I object to:  
Powerhouse Museum Renewal  
Application No SSD-32927319

1 BUILDING ENVELOPE 3D VIEW 2 - FROM SW CORNER Scale

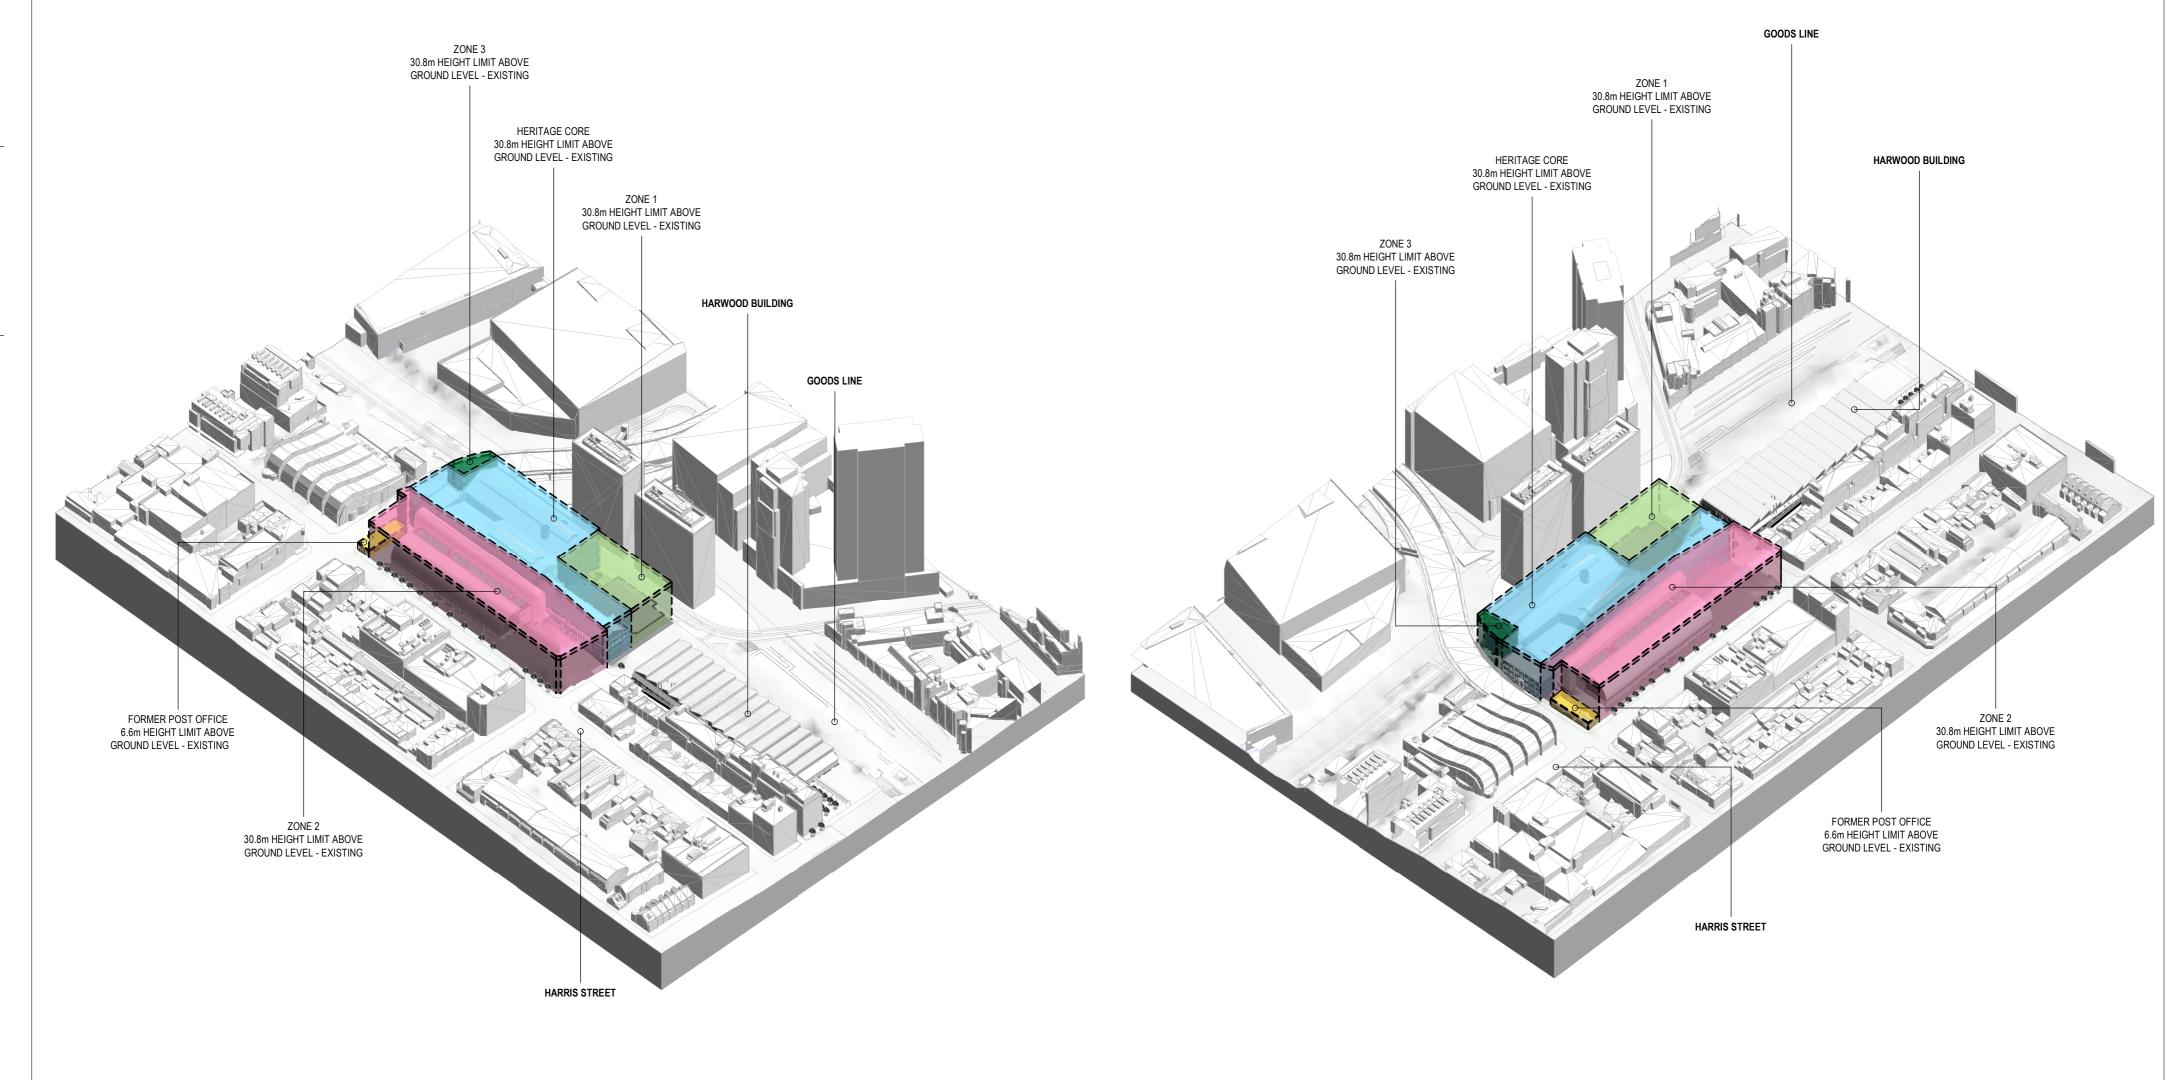
The Museum's renewal should enhance the local character and scale, pedestrian amenity and transport efficiency of Harris Street - not overpower this primary corridor which the proposed building envelopes along Harris Street clearly would, especially with the trendy but visually meaningless, overshadowing and obtrusive cantilevered levels.

I object to the proposed over scale envelopes for buildings (30m + for 'design excellence') along Harris St which are not only out of scale with the streetscape but also build on the public space of the Harris St forecourt of the Powerhouse Museum. The community would lose valuable public space in an area where open space is at a premium.

The bulk in height and width of the Building Envelopes on Harris Street are totally inappropriate as views along Harris Street are obscured and the bulk and height dominate Vernon's Ultimo Post Office.

The building envelopes encompassing the Boiler Hall and Turbine Hall along William Henry St would diminish the heritage impact and scale of the Boiler Hall and Turbine Hall if development occurs within this envelope and outside the dimensions of the Boiler and Turbine Halls.

Secondly, the current DA shows a 30m+ high Building Envelopes for redevelopment – totally out of scale and running the length of Harris St from Macarthur to the Post Office's curtilage, a monstrous development which would completely obscure any views of the Turbine Hall and Engine House from the direction of Harris St – and views of the Vernon Post Office.
